**Re: Locust Project, 809 Locust SE, Traffic Circulation Layout  
Engineer's Stamp dated 12/05/13 (K15-D096)**

Based upon the information provided in your submittal received 01/10/14, the above referenced plan cannot be approved for Building Permit until the following comments are addressed:

DRAWING TITLE: **TRAFFIC CONTROL LAYOUT**

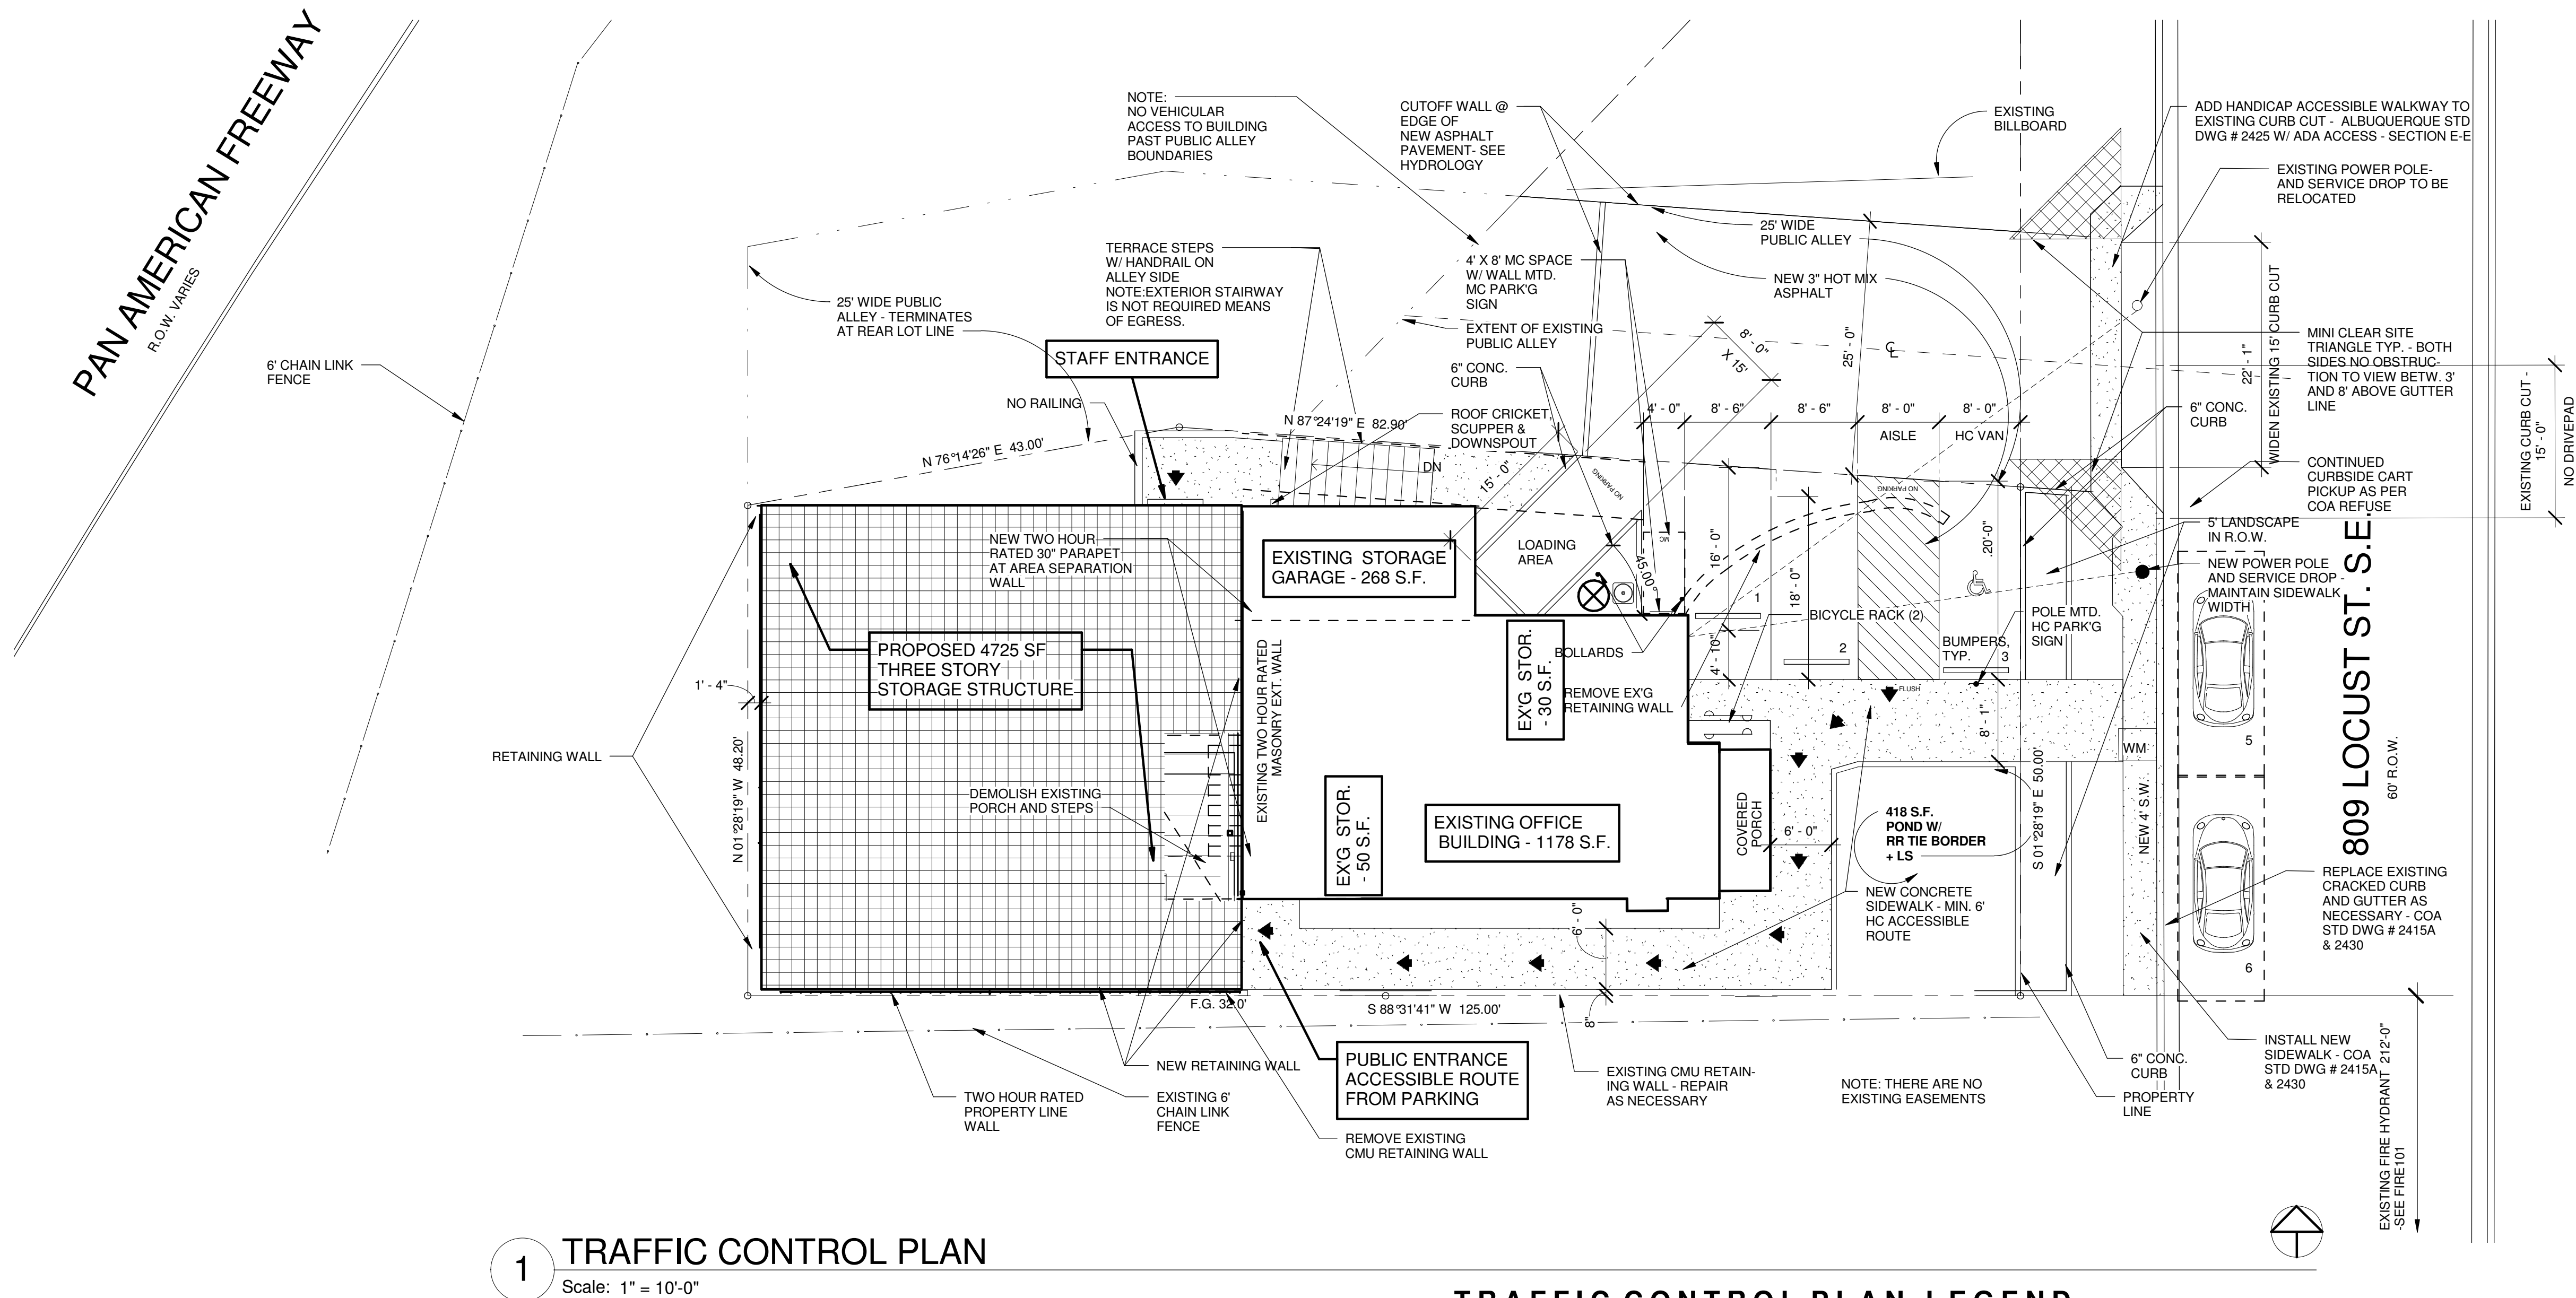
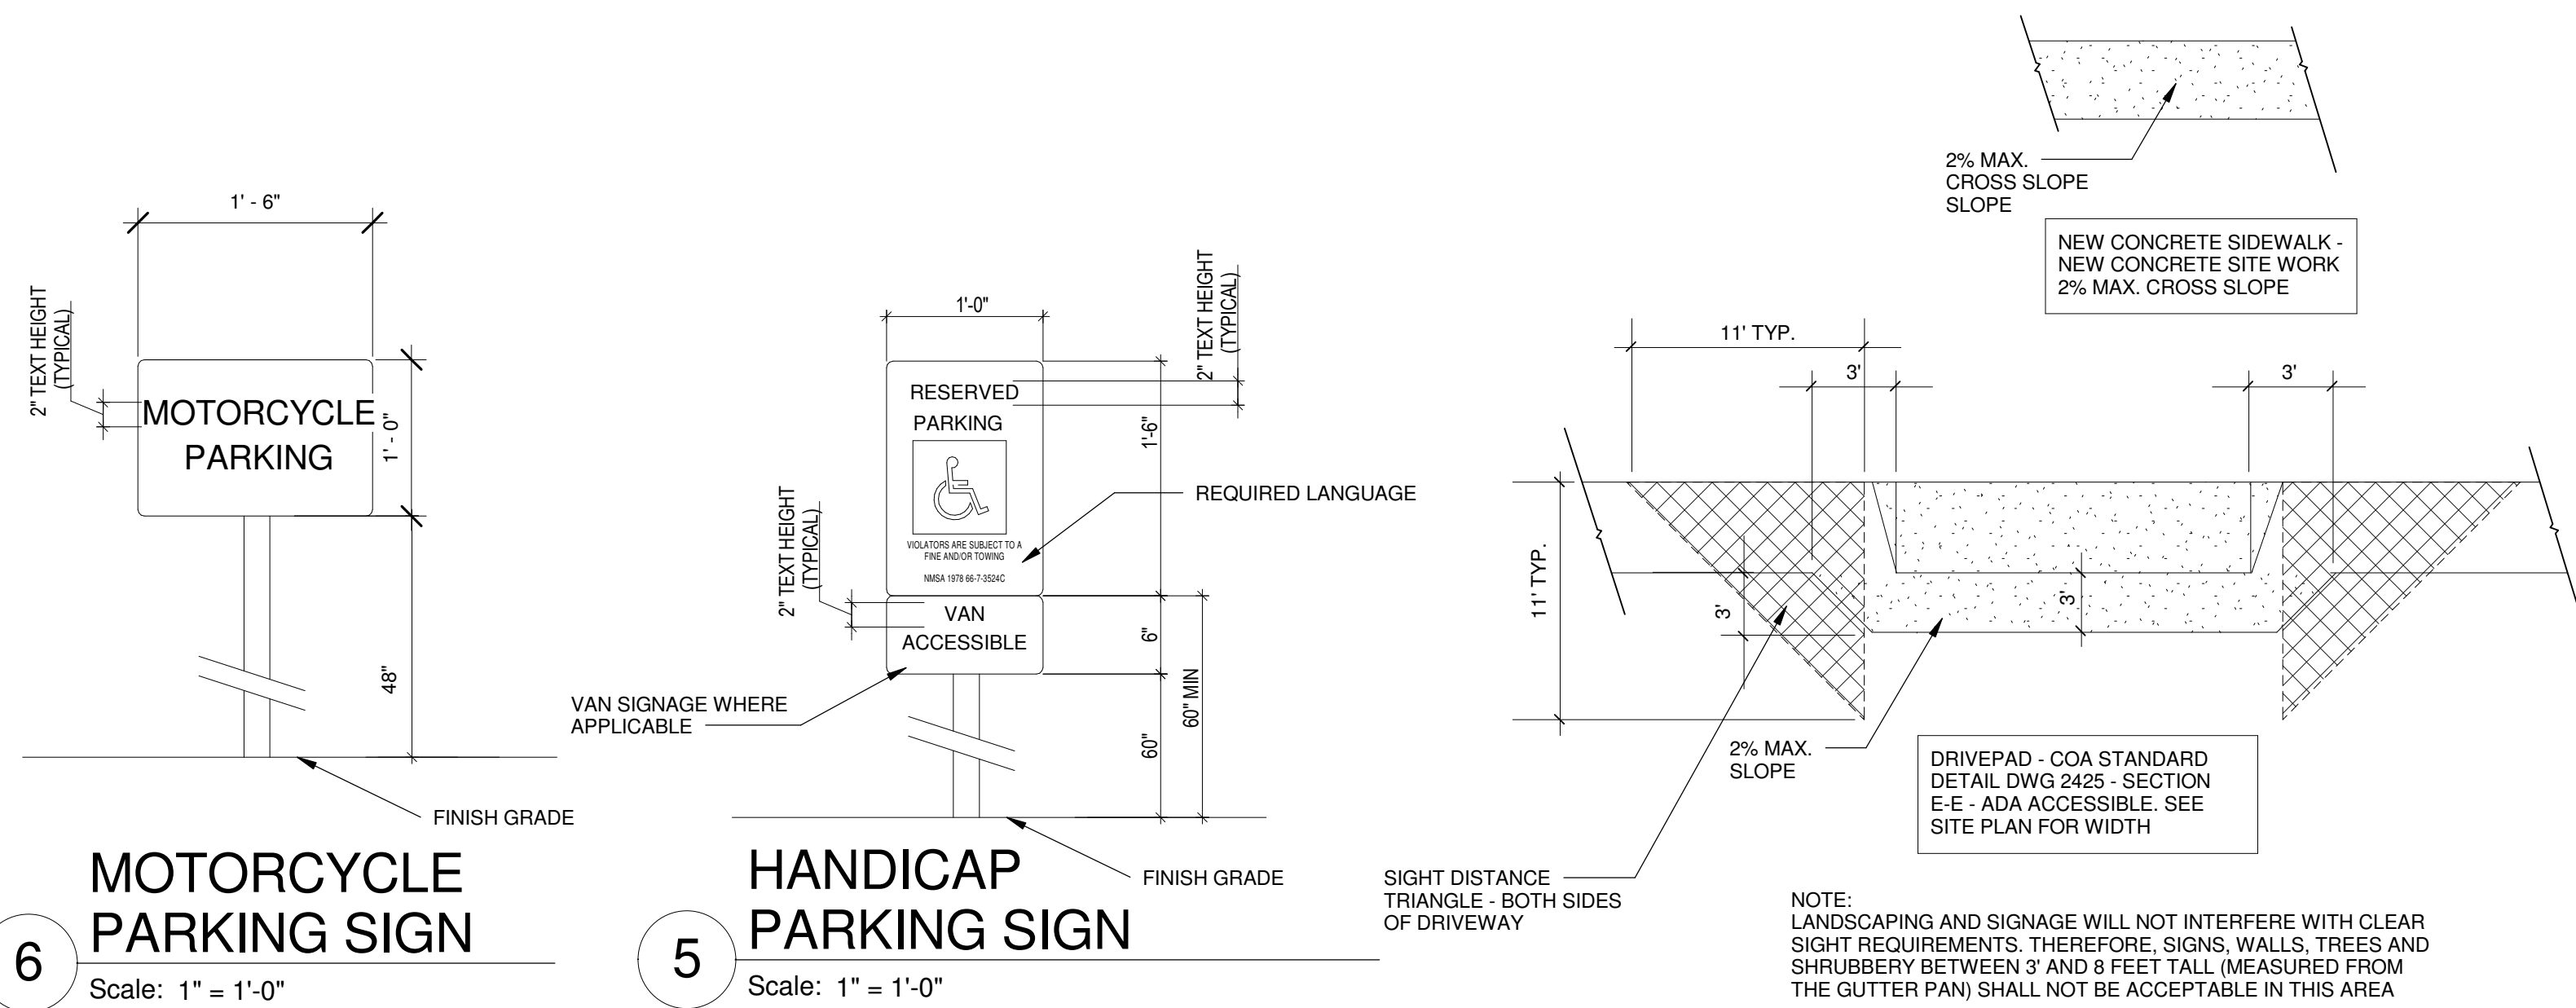
1. Please show a vicinity map.
2. Please refer to all applicable city standards.
3. Please ensure all ramps are ADA compliant.
4. Please provide a plat of the property.

5. Please provide documentation that alley way extends the depth of property to allow access to the proposed storage building.
6. Please list the width and length for all parking spaces.

7. Provide the width of parking lot drive aisle. Per DPM, two-way vehicle movement requires 24ft drive aisle width.
8. Please show the location of the nearest curb cuts on the adjacent lots.

9. Label the width and location of any existing drivepads.
10. List the width of the proposed driveway and provide details or appropriate city standard.

11. Show a detail of the wheelchair ramps located at the proposed driveway, or refer to the appropriate city standard.
12. List the number of parking spaces required by the zoning code as well as the proposed number of parking spaces.

13. Per the DPM, a 6 ft. wide ADA accessible pedestrian pathway is required from the public sidewalk to the building entrances. Please clearly show this pathway and provide details. Additionally, the pedestrian pathway must not share the vehicular pathway. If pathways are parallel, a physical barrier (i.e. raised curb) must be provided.

14. Is landscaping required by zoning? If so, please provide landscaping plan with next submittal. Per the *Development Process Manual*, Chapter 23, Section 7, Part B.6, curbing should be used to separate landscaping from

parking areas and pedestrian ways as well as providing a physical perimeter for harvesting water. This must be clearly shown on the TCL.
